From: Susan Leeson
Sent: 06 January 2012 11:43
To: 'Dawn Appleton'
Subject: BE/151/11 Shripney Caravan Park

SHRIPNEY GARDEN CARAVAN PARK, SHRIPNEY LANE, SHRIPNEY
Proposals 01
Nov 2011

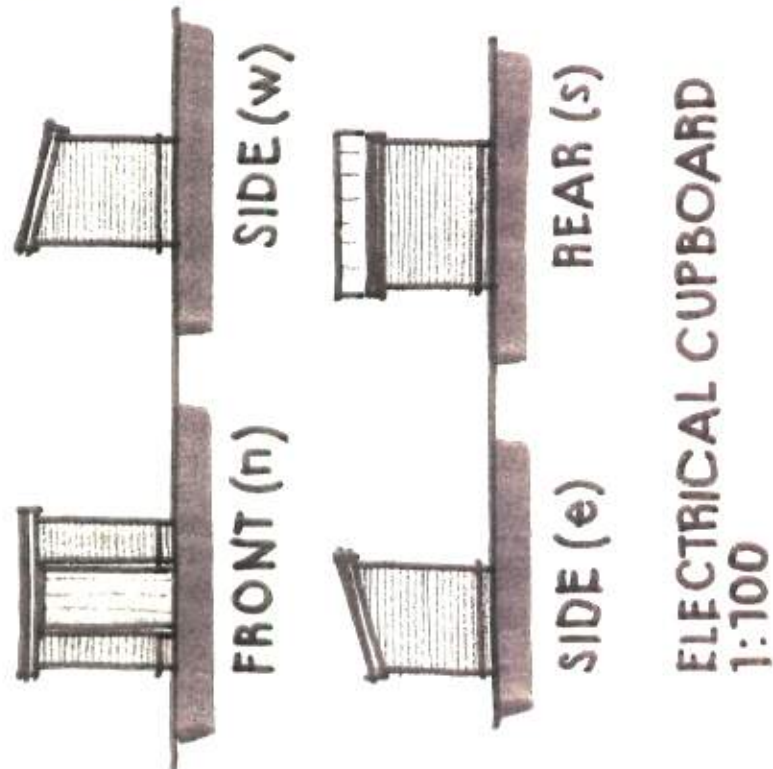
- 1/ A detailed landscape plan, showing screening along the roadside and along the boundary with Myddleton Terrace.
- 2/ A revised layout plan showing caravans 10,11 and 12 as per the original locations as approved by BE/42/10.
- 3/ The access gate located back another 7m into the site to allow a buffer between the access and the end of Myddleton Terrace.
